From: DataSpace Consult [system@dataspaceconsult.co.uk]
Sent: 13 November 2014 15:03
To: Planning
Subject: Comments Added: Land off Comet Way Hatfield

Application ID: S6/2014/1443/MA Duty Officer Application Owner: Welwyn & Hatfield Borough Council (Development Management Officer)
Applicant: Absolute Interiors
Location: Land off Comet Way Hatfield
Deadline Date: 13/10/2014 00:00:00
Description: Erection of new public house and associated works Comment Added:

Comment: Response in relation to the noise management report and ventilation consultants information:

Drawing Title:
Exterior Shelter

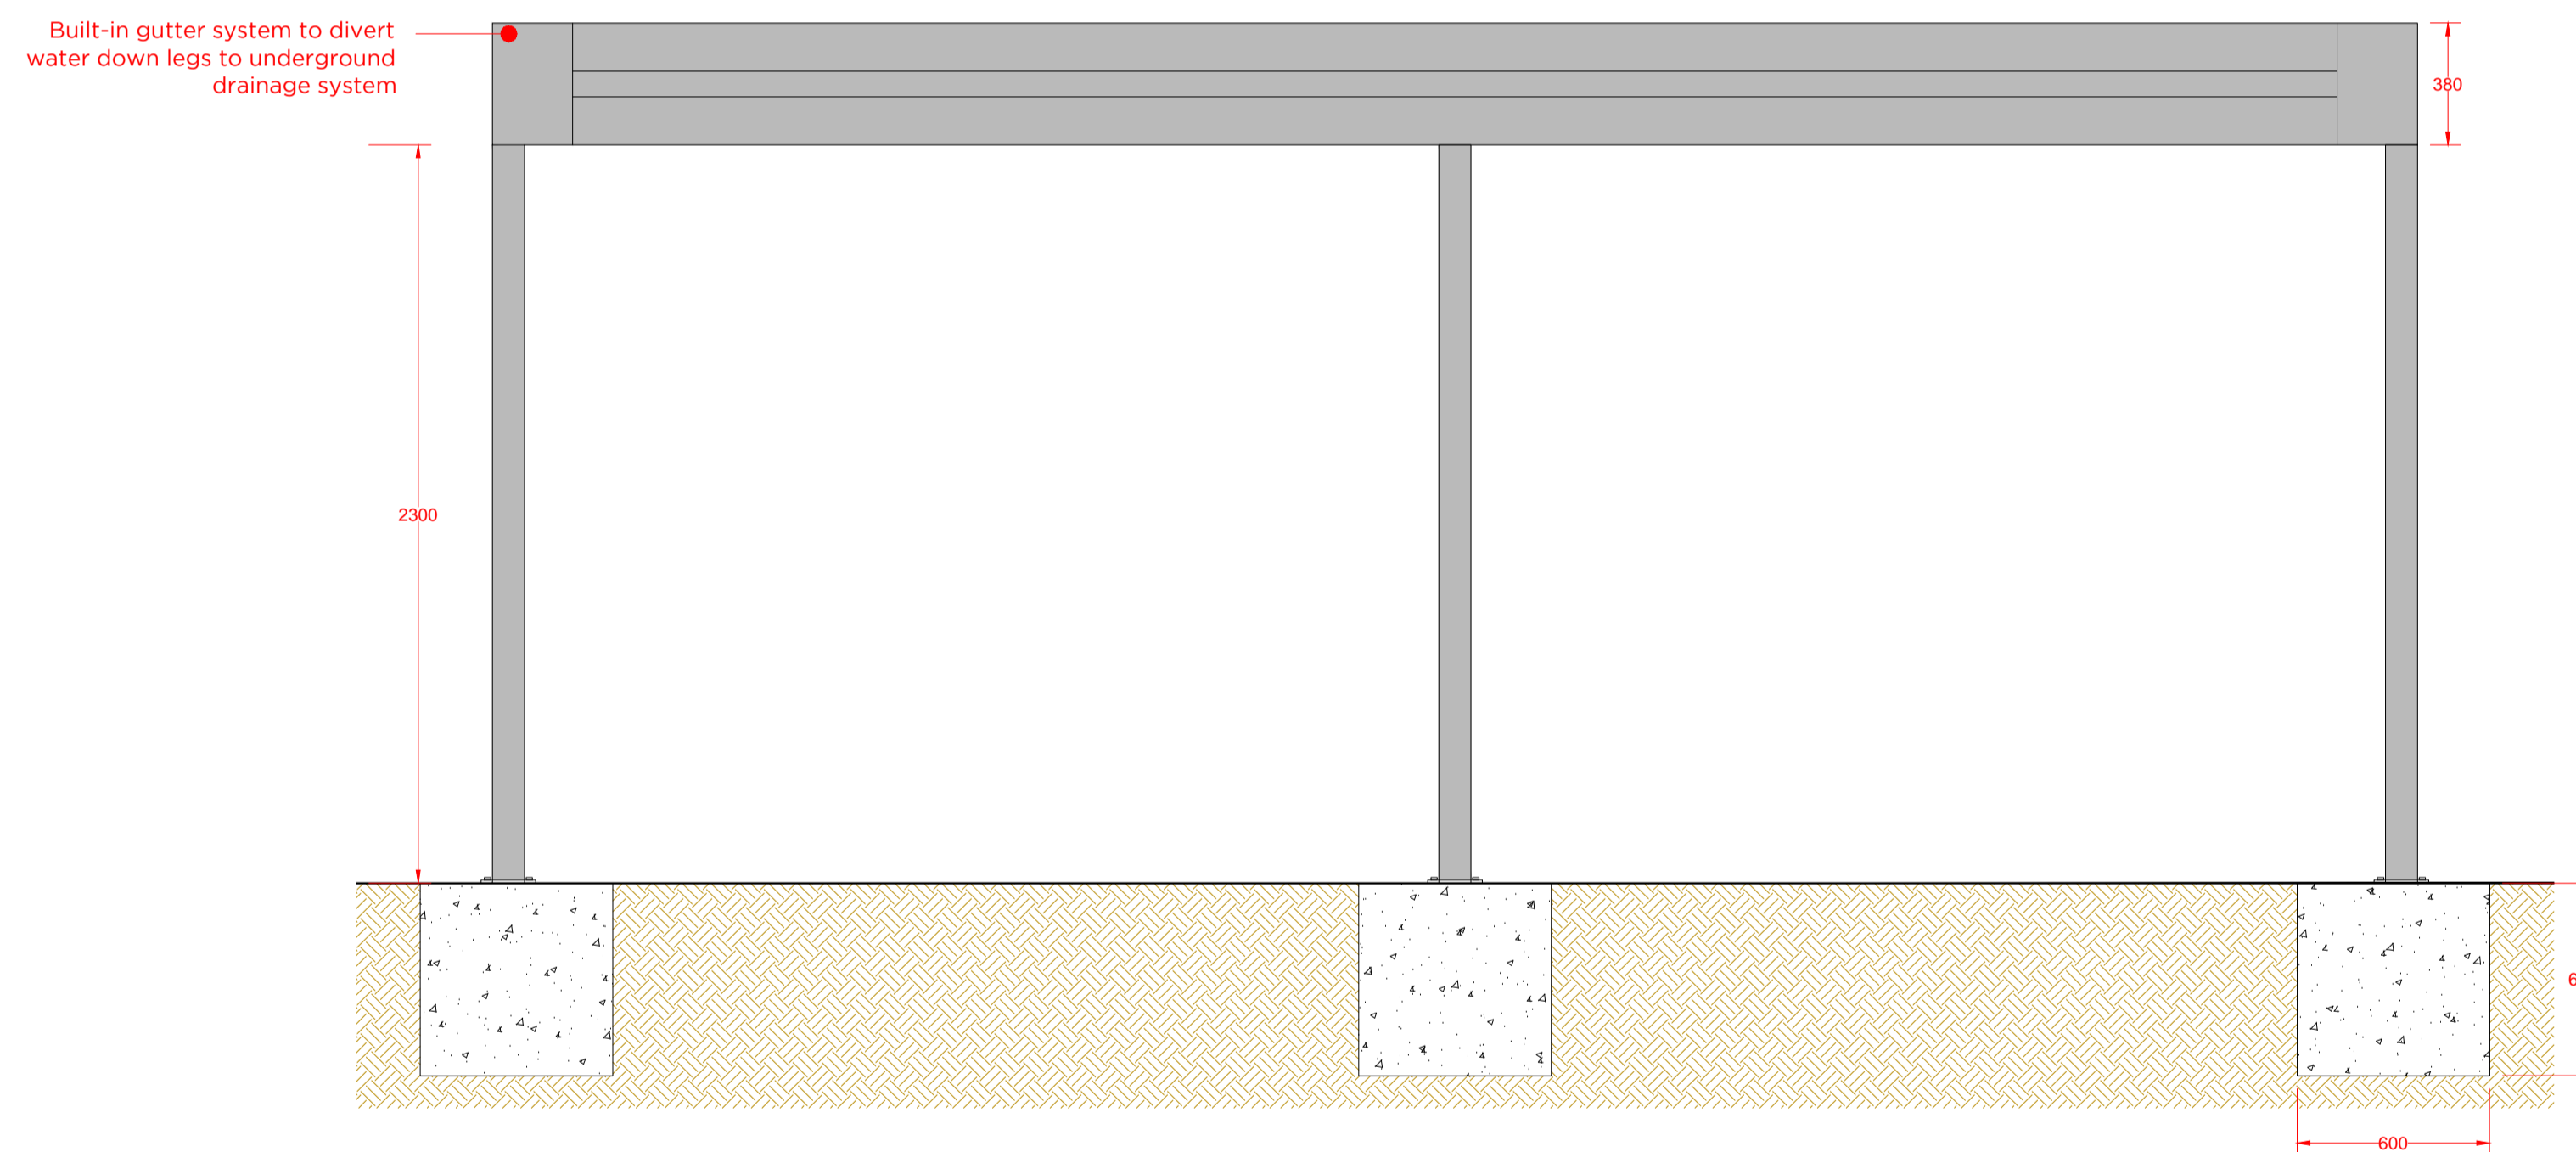
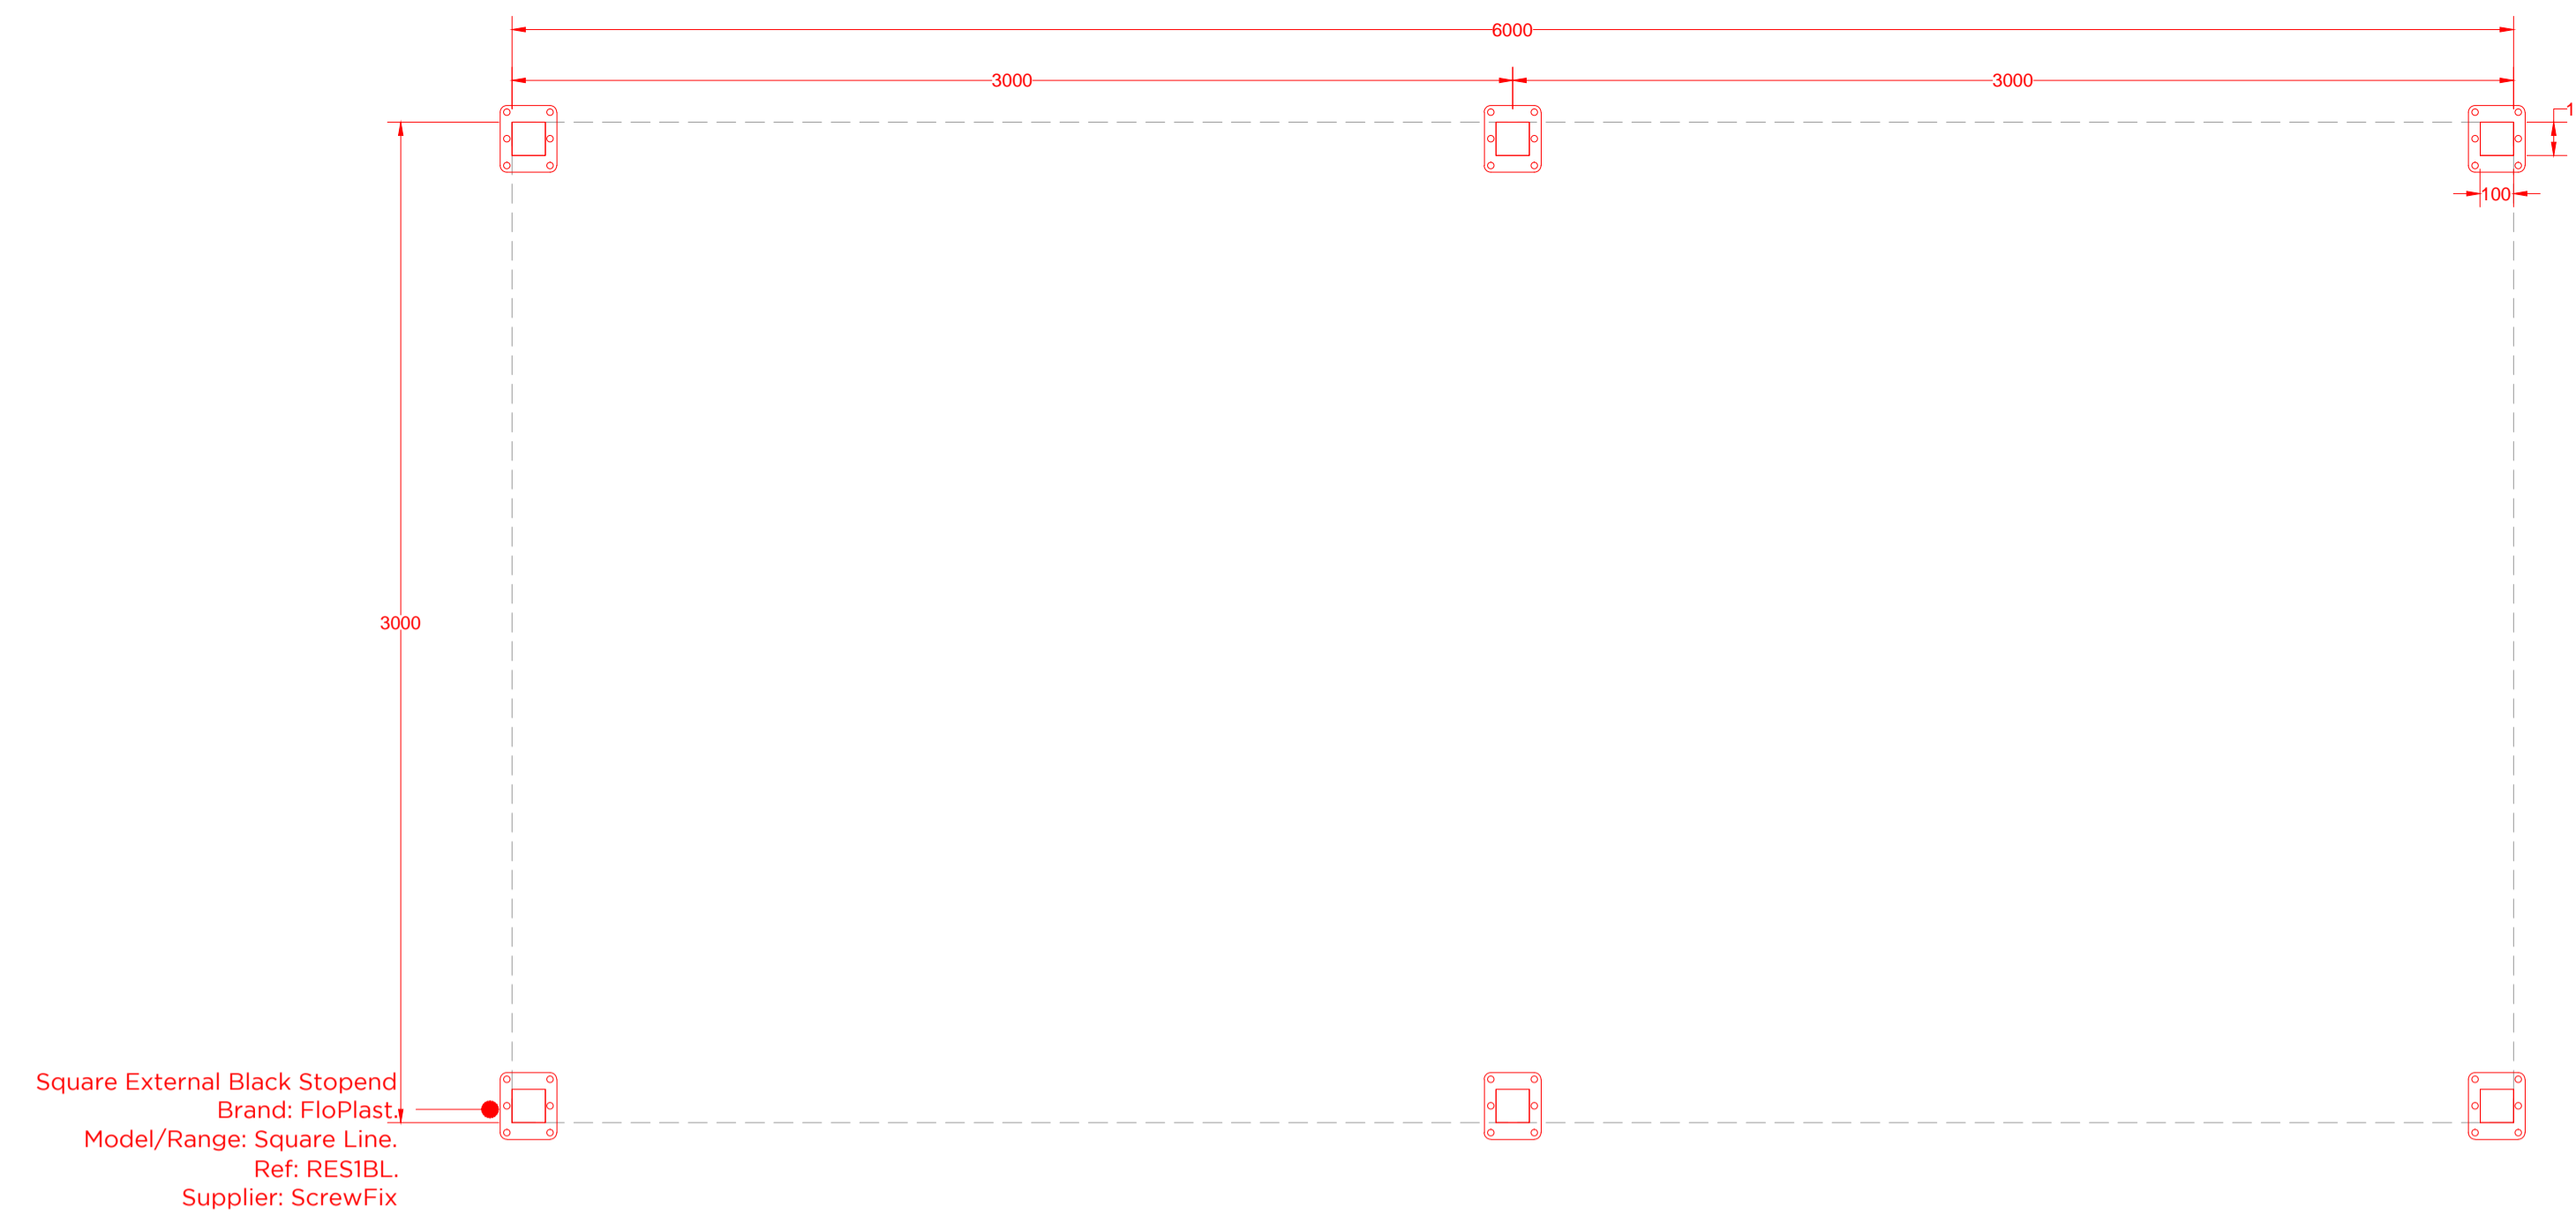
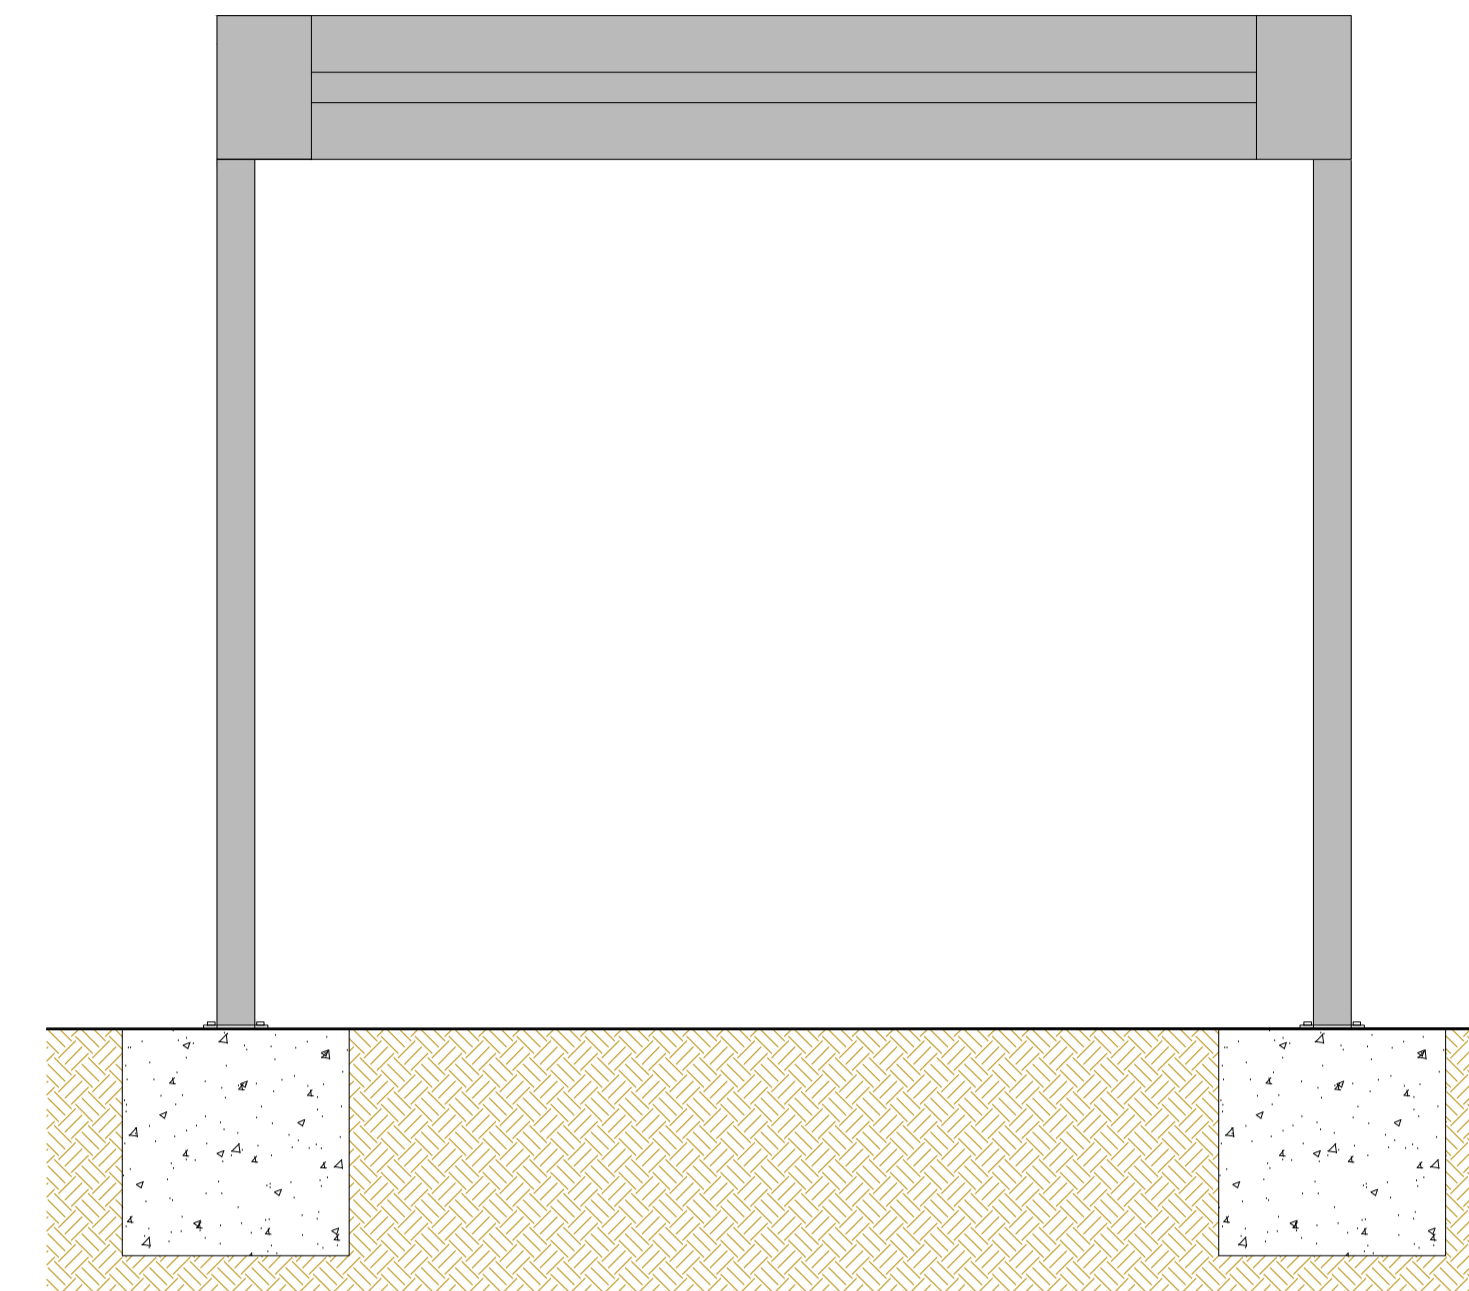
5. The position of the smoking shelter is not appropriate and should be moved to the opposite end of the beer garden (also required via licensing and for the installation of a gate).

01 GROUND FLOOR PLAN
1:100 @A1

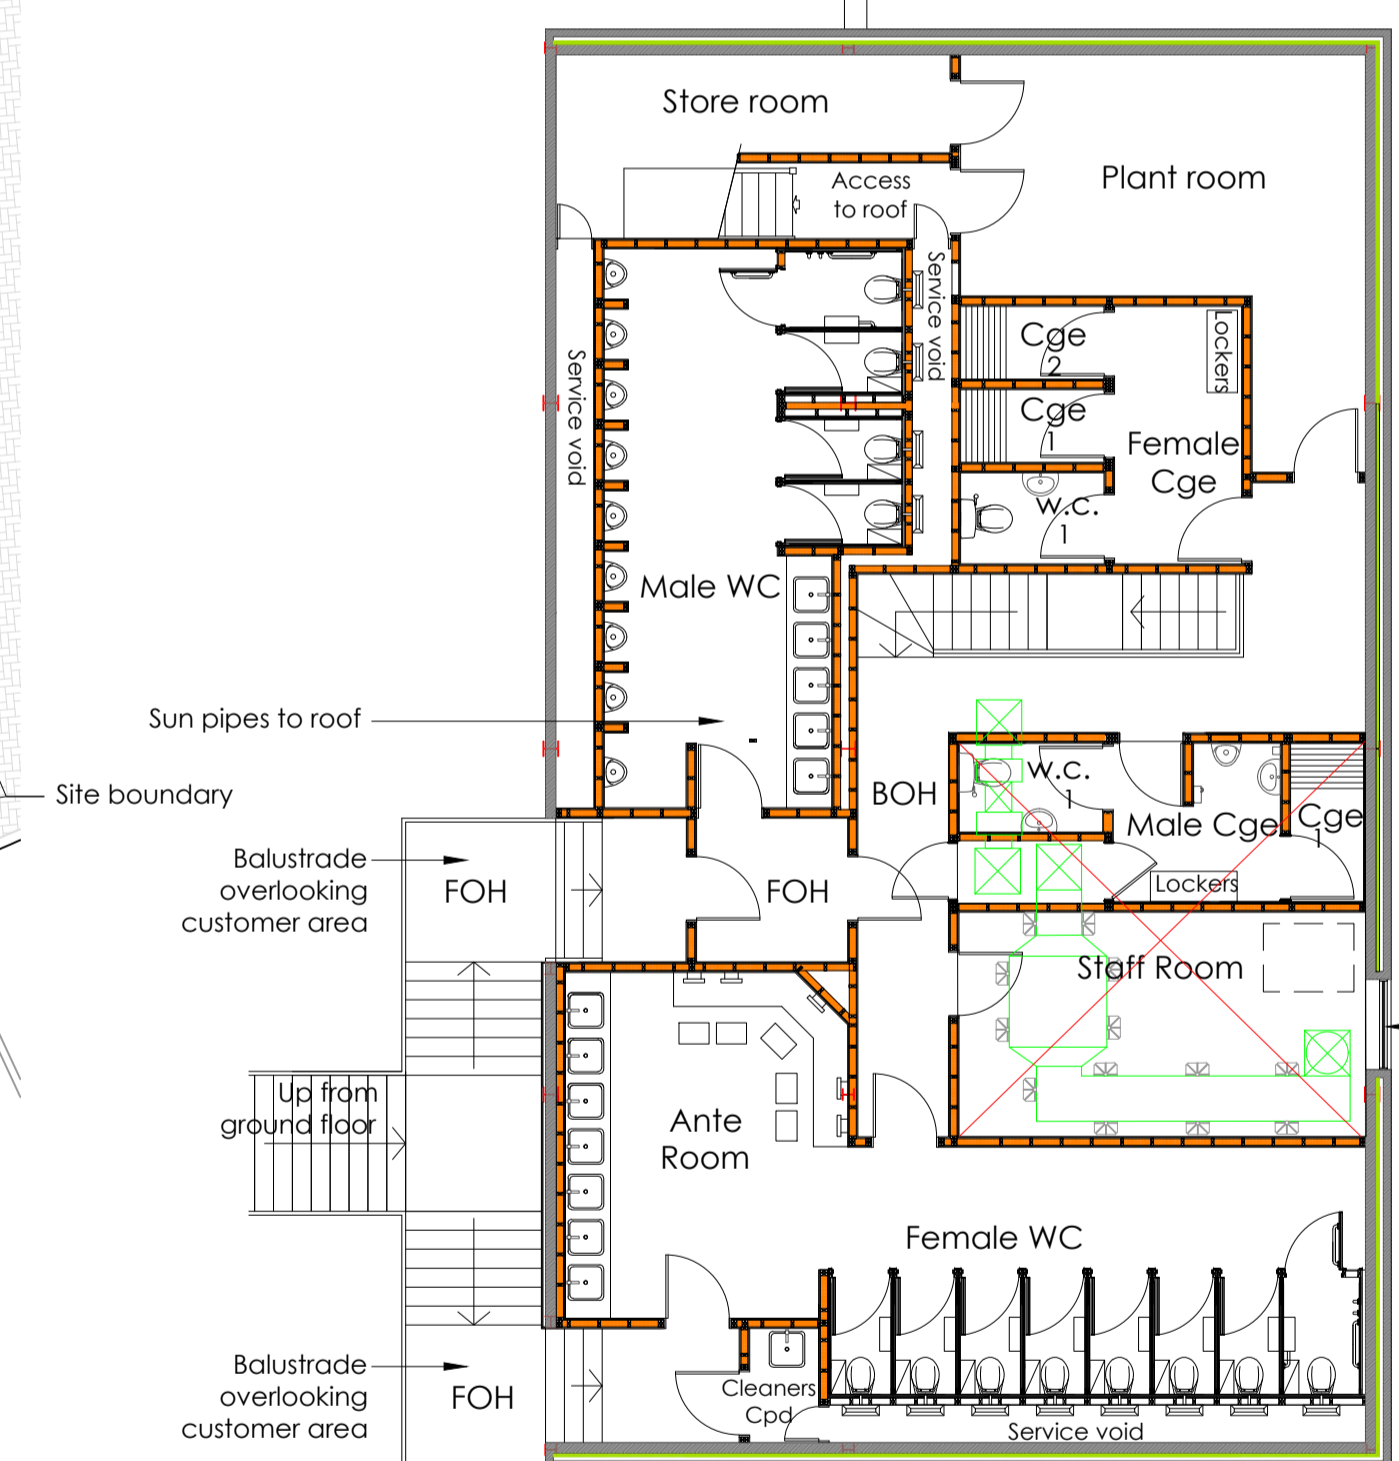
6. The position of the entrance and exit doors to the beer garden faces directly towards the hotel. This just be moved to a position 90o away from the hotel.
